Engineers Comments Regarding Surface Water Drainage

Application Reference:	WA/11/25/DOC	Reviewer Reference:	ADC/SB
Planning Officer:	Hebe Smith	Date of Review:	05/12/2025
Site Name:	Snetterton West Walberton Lane Walberton BN18 0QS		
Application Description:	Approval of details reserved by condition imposed under WA/46/22/HH relating to condition 3-surface water drainage.		
Assessment Number:	3 of 2

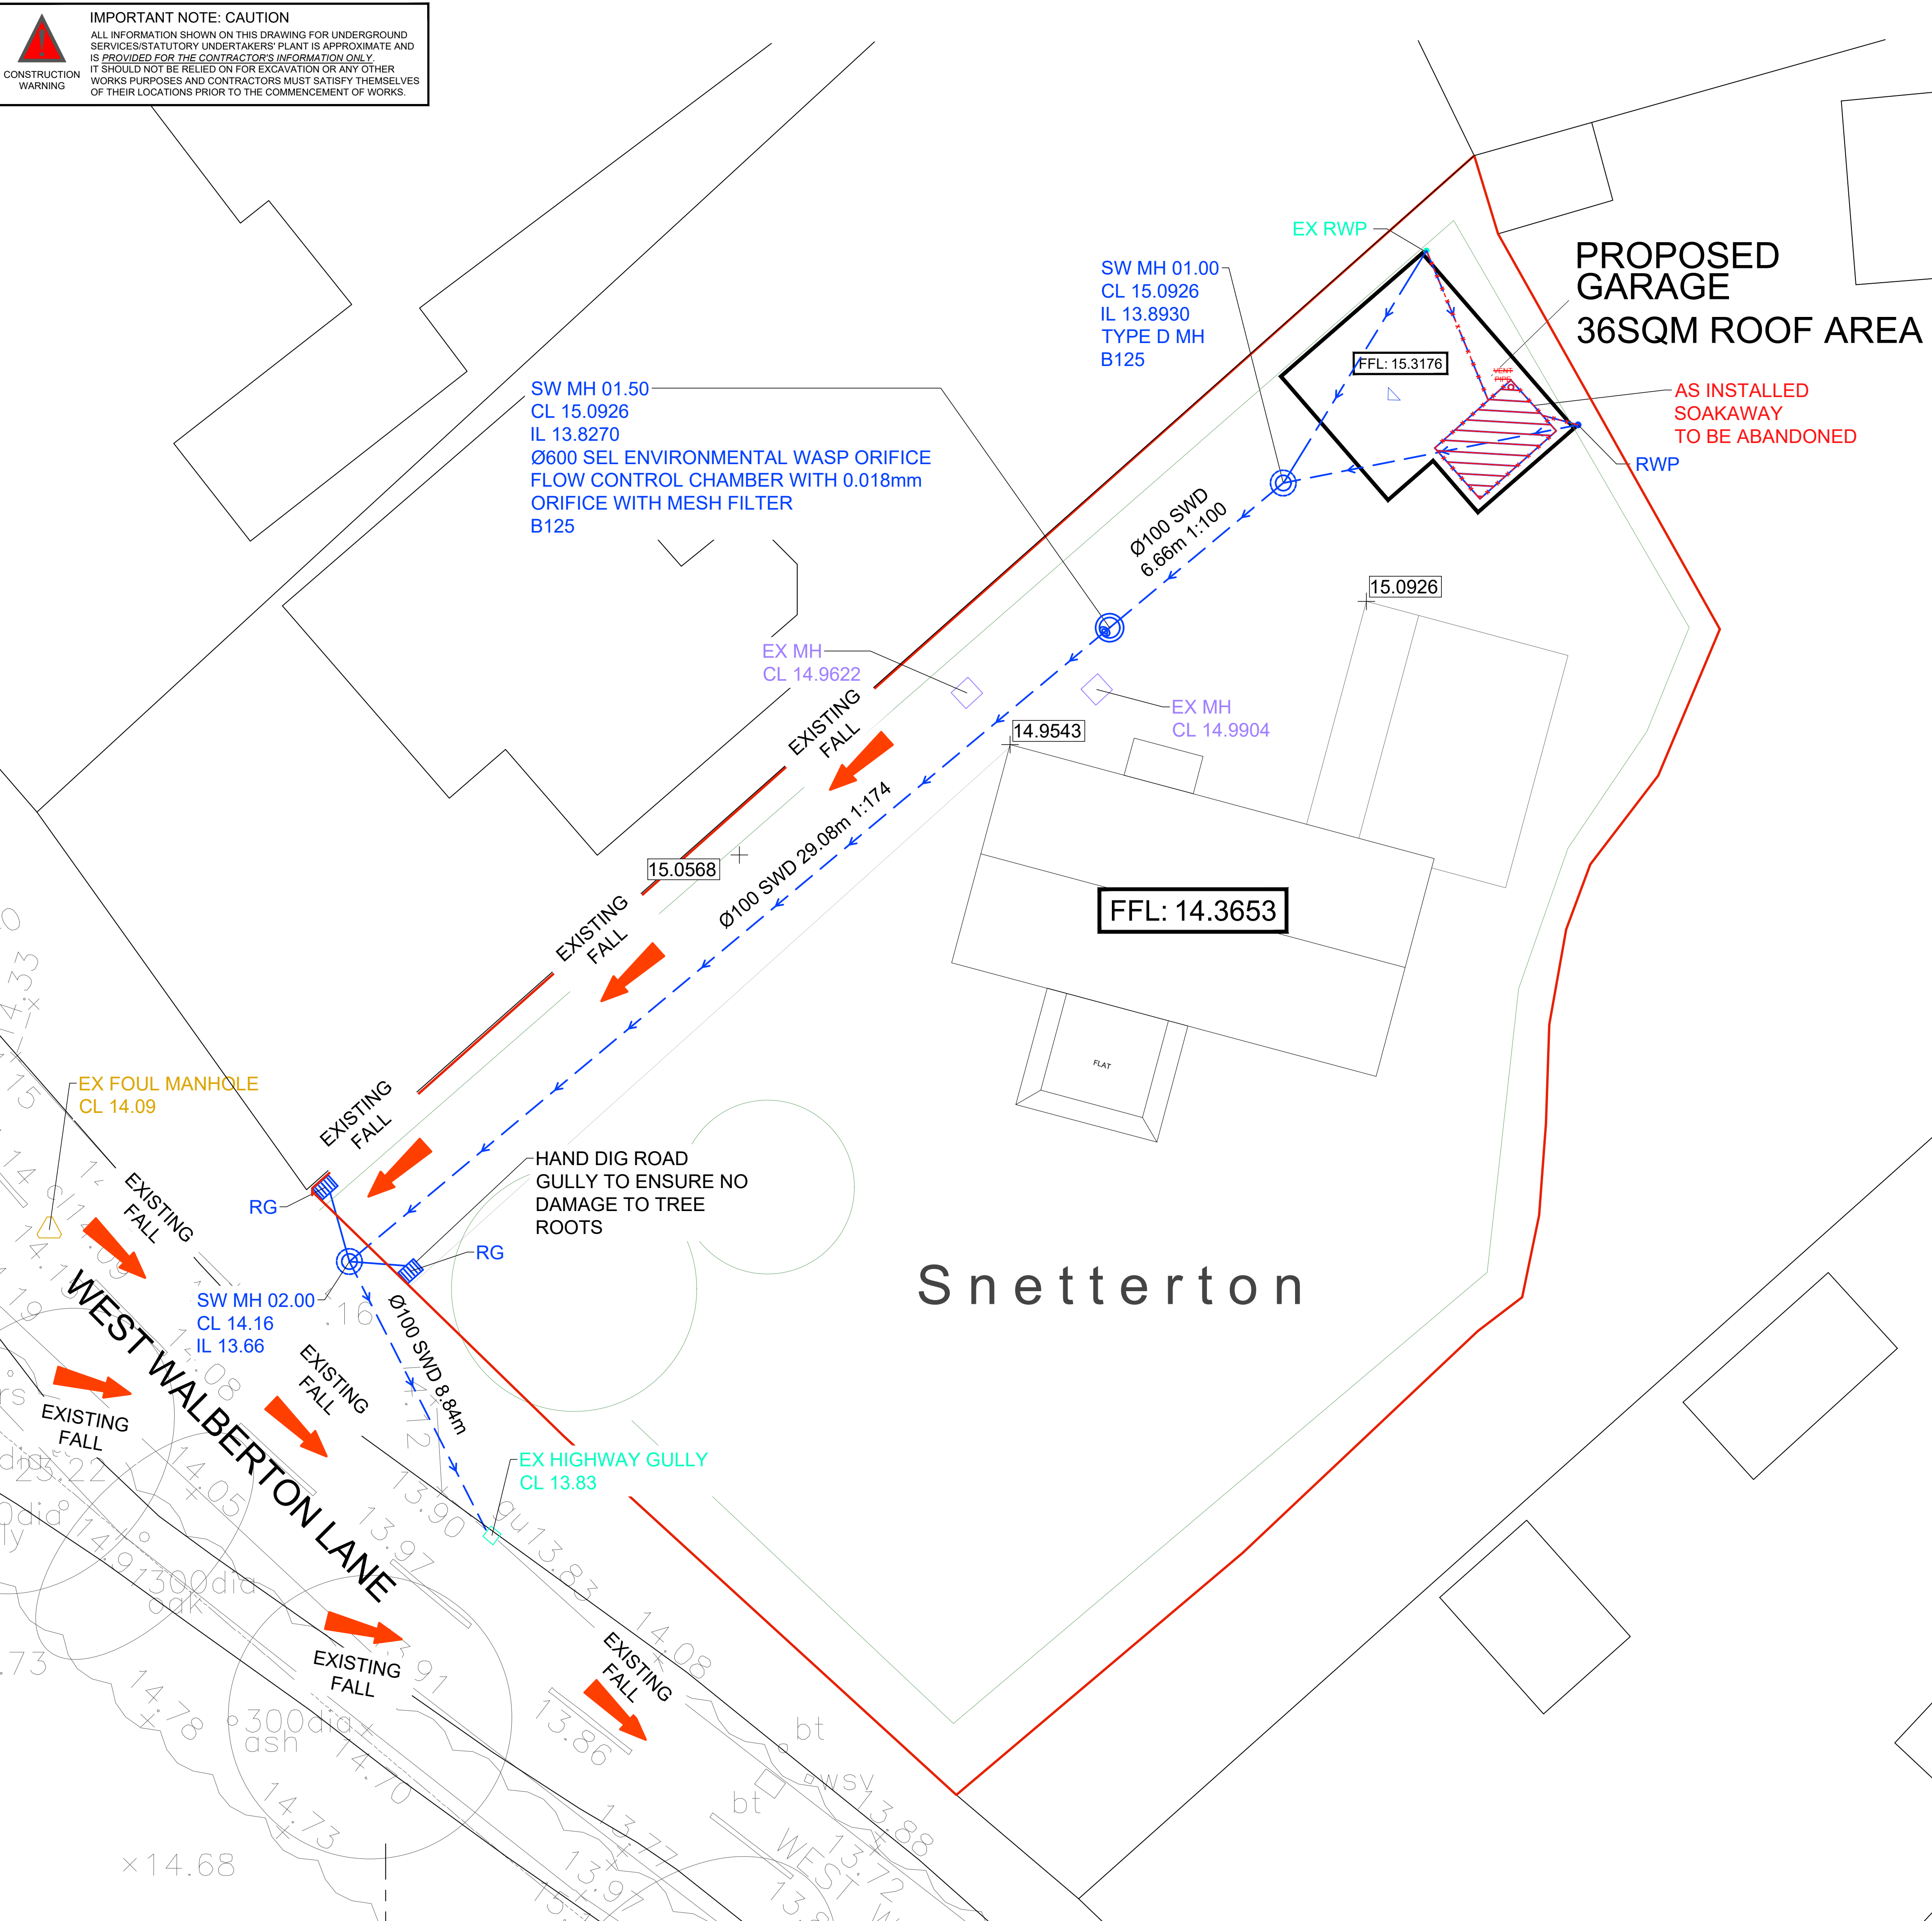
8.	Please submit calculations to support the design – refer to the attached checklist for requirements.	Thank you, but the design is still allowing infiltration, and the overflow is unrestricted. Best practice design rules are unchecked. The garage is	The pipework between MH SW 02.00 and the existing road gully needs to be included in the calculations. CV values for all events must be set to 1. This includes summer, winter, design, and simulation events. Urban creep needs to be applied;	Pipework between MH SW 02.00 and Existing Highway Road gully added CV set as 1 for winter and summer 10% Urban Creep has been applied FEH 22 used, excel attached	Noted. It is unclear how the surcharged outfall has been modelled. The surcharged outfall is normally specified as such in the simulation settings. In the calculations, an additional flow control has been added to SW MH 02.00?? Please explain/adjust.	A 1mm orifice was put on the EX HW RG note to represent no flow through the gully due to it silting up. Revised calculations attached with a surcharge outfall using the Hydrograph section of Flow	Two sets of calculations have been provided, one with a surcharged outfall and the other not. The set without a surcharged outfall should be labelled as such (both currently labelled as surcharged). Following the redesign of the pipework/chamber

16.			The gradient of pipe length SWMH 01.50 to 02.00 is slacker than the minimum permissible gradient for a 100mm pipe. A minimum 1 in 100 gradient or steeper must be achieved.	Gradient amended to 1:100	Noted. Comment closed.	CLOSED

17.			The proposed surface water drain is shown running between two existing manholes adjacent the house. Assuming these relate to existing foul drainage, please provide details ie. pipework configuration, diameters, invert levels). This is to ensure that the proposed surface water drainage does not clash with existing pipework, in terms of levels.	Inverts of foul drainage added, the proposed surface water run is deep than the existing foul drainage so there is no clash	Noted. Comment closed.	CLOSED

20.			Proposed manhole SW MH 02.00 may be located in public highway. Please provide evidence that this is acceptable to WSCC.	This has been moved to the end of the drive	Noted but see comment no.5. Comment closed.	CLOSED

21.			The proposed road gully directly east of MH SW 02.00 is connecting against the flow in the pipeline and will need to be reconfigured.	This has been resolved with a standard 450 dia radius on the outlet pipe so that the PPIC can be oriented to have the gullies coming in the side	Noted but see comment no.5. Comment closed.	CLOSED

22.			Specify proposed discharge rate on drainage layout plan.	Added to plan	Noted. Comment closed.	CLOSED	
23.			Flows to be restricted to 0.5 l/s for all storm events.	Noted, maximum rate for the 1:100+45% storm is 0.5l/s	Noted. Comment closed.	CLOSED

24.					Upstream of SW MH 01.00, where there are rodding eye arrangements. Please either replace this arrangement with new manholes at the points of redirection or show the rodding eye arrangement more clearly ie. indicate the pipes downstream of the RWP's connecting just downstream of the rodding points via oblique 45 degree junctions.	RE moved further away from point of connection	Noted. Comment closed.
-----	--	--	--	--	--	---	------------------------
